Subject: Planning application for fencing at 9 Pinewood Close

Mr. Shipway I have visited the site in connection with your application.

Drawing Title
Block Plan

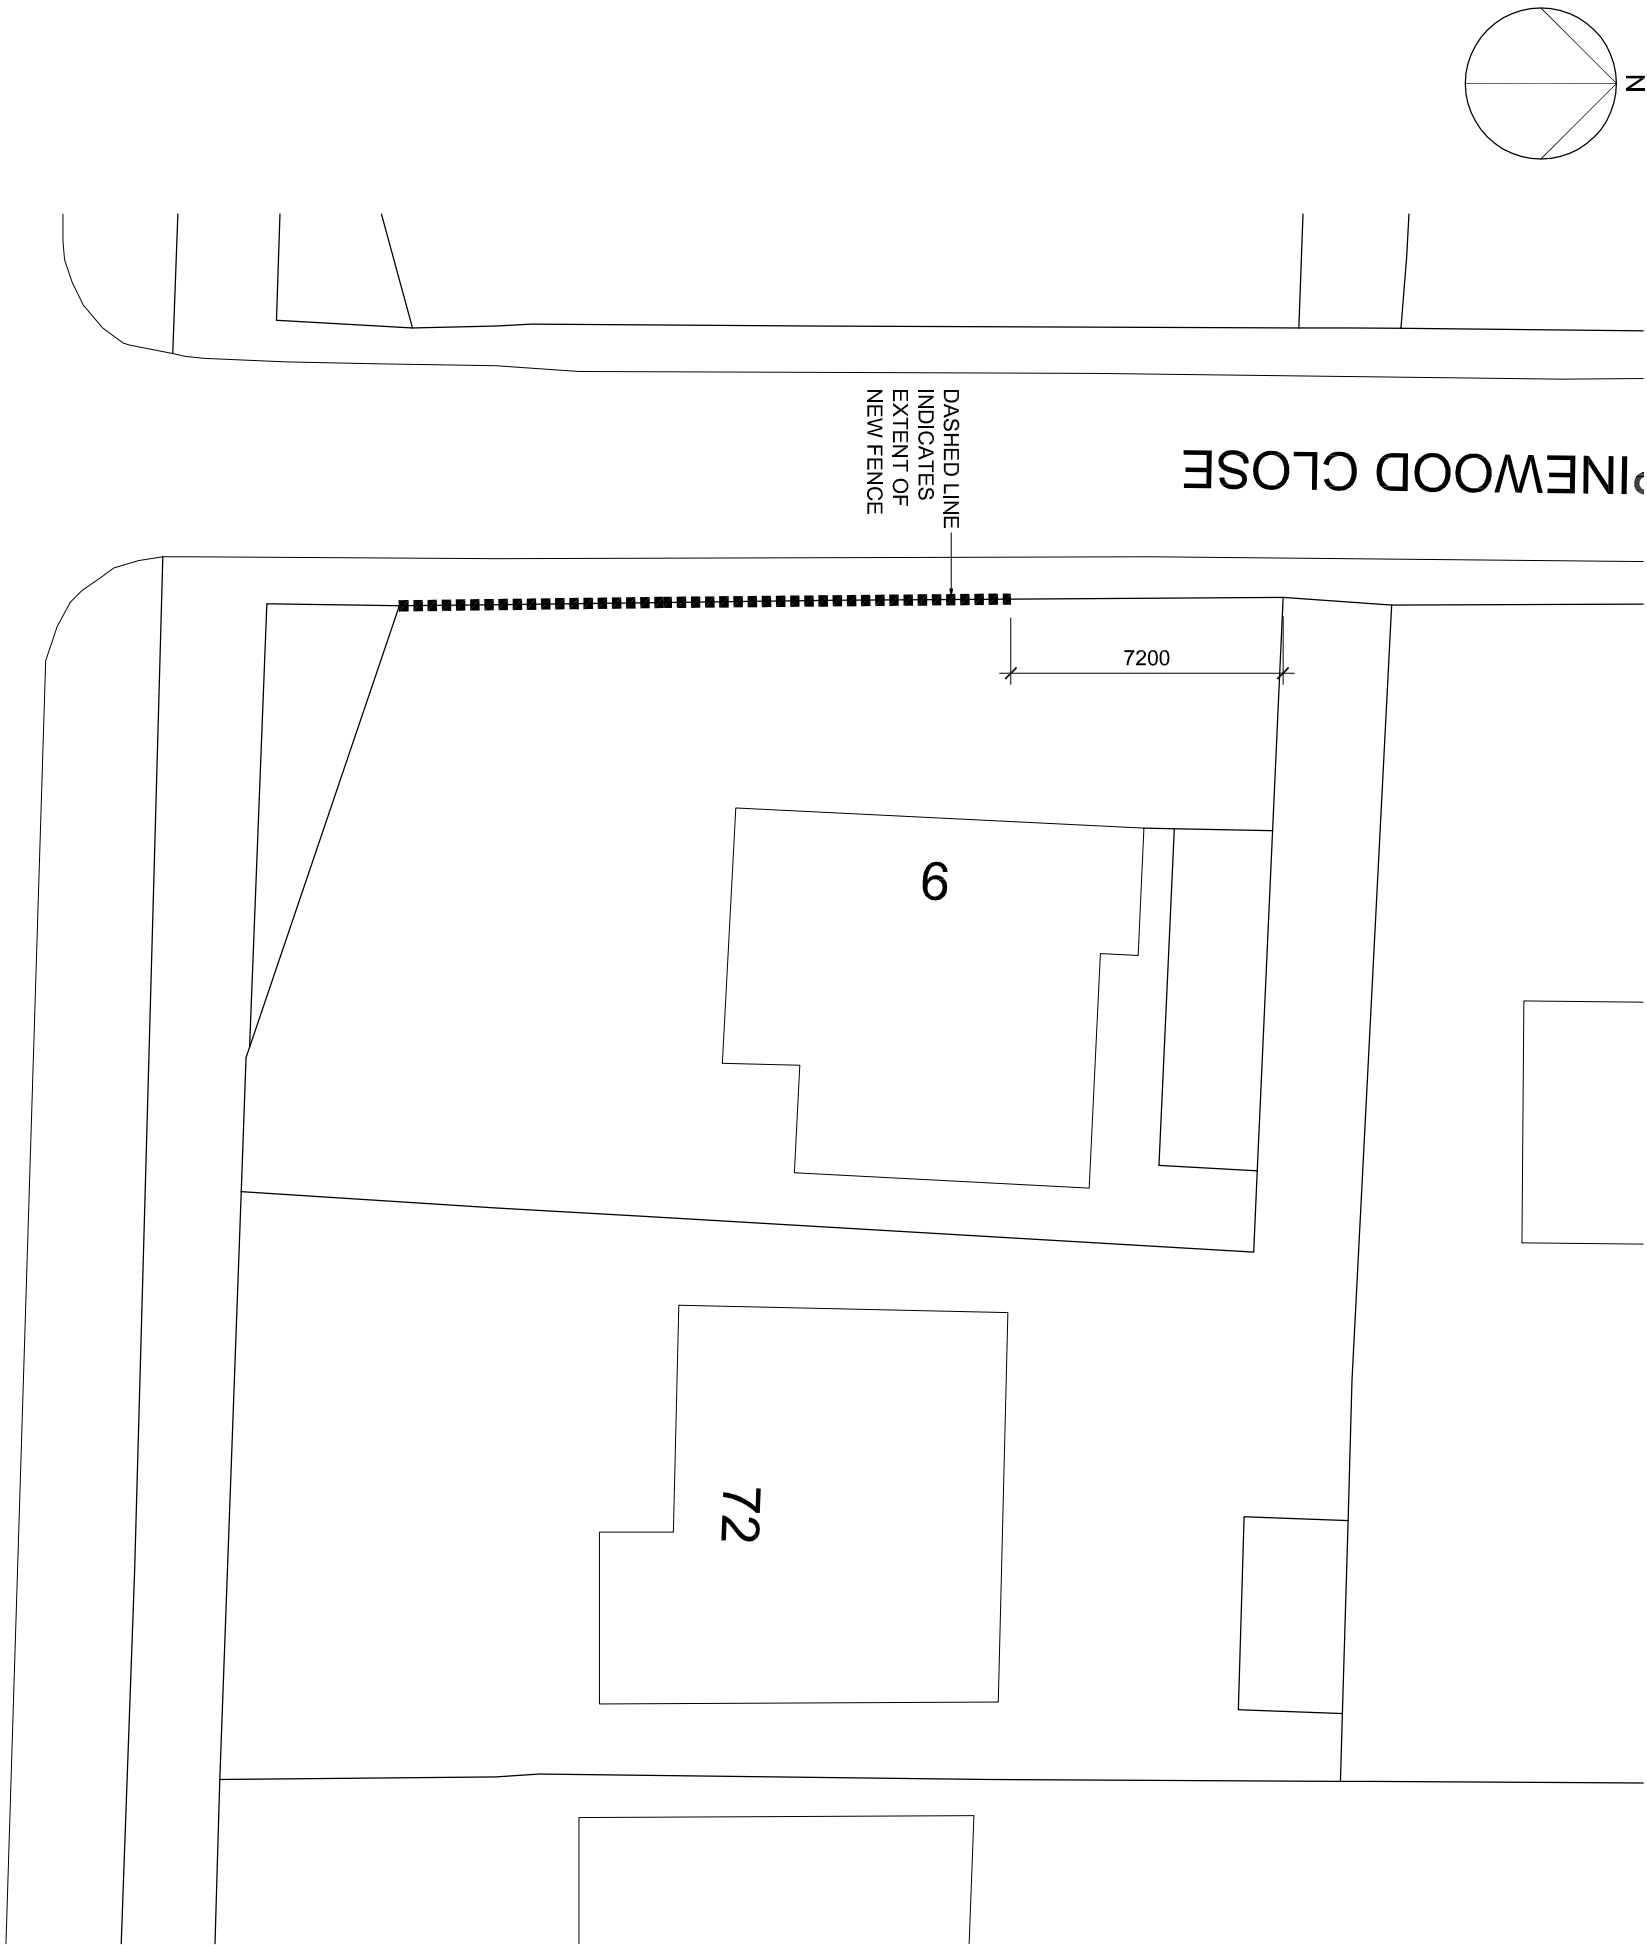
I note the property has the benefit of hedging and trees along the boundary in question and the application form advises that no trees or hedges will be removed as confirmed at sections 7 and 11. However the submitted plan indicates that the fencing will run along the boundary line which cannot happen without the removal of trees and hedges.

Please advise whether it is intended to run the fencing on the boundary thereby resulting in the loss of trees and hedges or that the fence is to be set into the site behind the line of existing growth. If the latter case you will need to submit a revised block plan (1:200) which clearly shows the fencing sited clear of the vegetation.
